Re : Kirklees Planning Application Number 2024 / 92371

I again refer to the above Planning Application which outlines my next-door neighbour's application for the erection of front and side extensions with alterations to the roof and associated works, and I comment as follows :-

NORTH ELEVATION

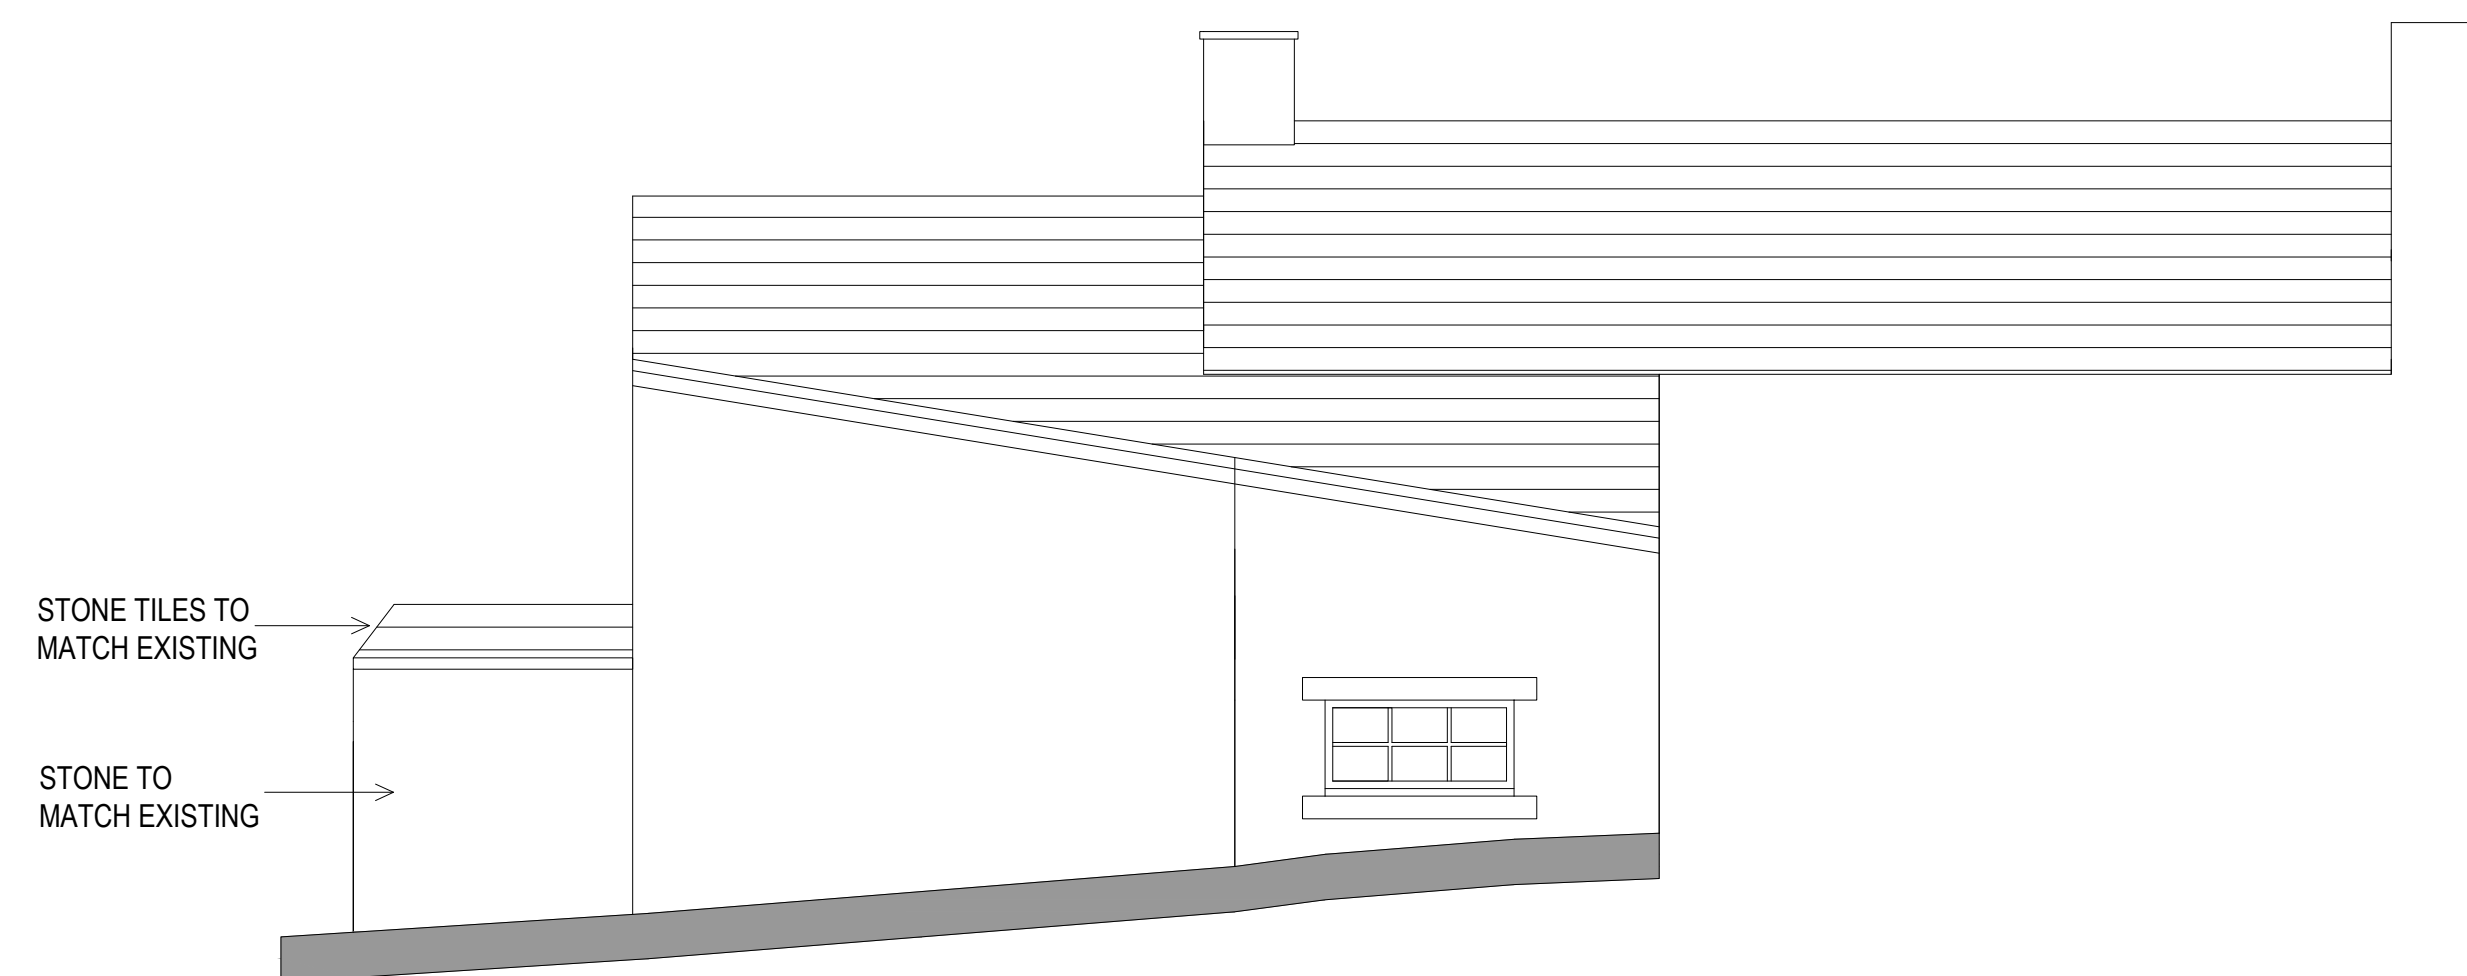
I have concerns regarding the proposed roof alterations which when looking on the 'North Elevation' on the attached drawing shows that the proposed roof alterations would mean that I would lose my window in my north east gable end of my property.

This window which I refer to is my window shown in the attached top photo above the flat roof to the right hand side just below my roof, i.e. the square shaped window in the triangular shaped gable end of my property.

In view of my comments as noted above, I would appreciate it if the proposed plans be revised so that I don't lose my window in my North East gable end of my property.

My reason for this is that having spoken with N , I am now quite happy for N 's proposed extension to be constructed all as shown in the attached drawing subject to N paying for a new roof velux window in my adjacent roof.

N has agreed to provide this new roof velux window in my property's roof with the velux window to be located roughly half way along my roof between my grey dustbin and my window as shown in the attached bottom photo. This new velux window will replace my existing window in my gable end to provide light into my property. My existing window in my gable end will be removed with the opening then built up with stone to allow N 's new roof extension to joint up against my roof.
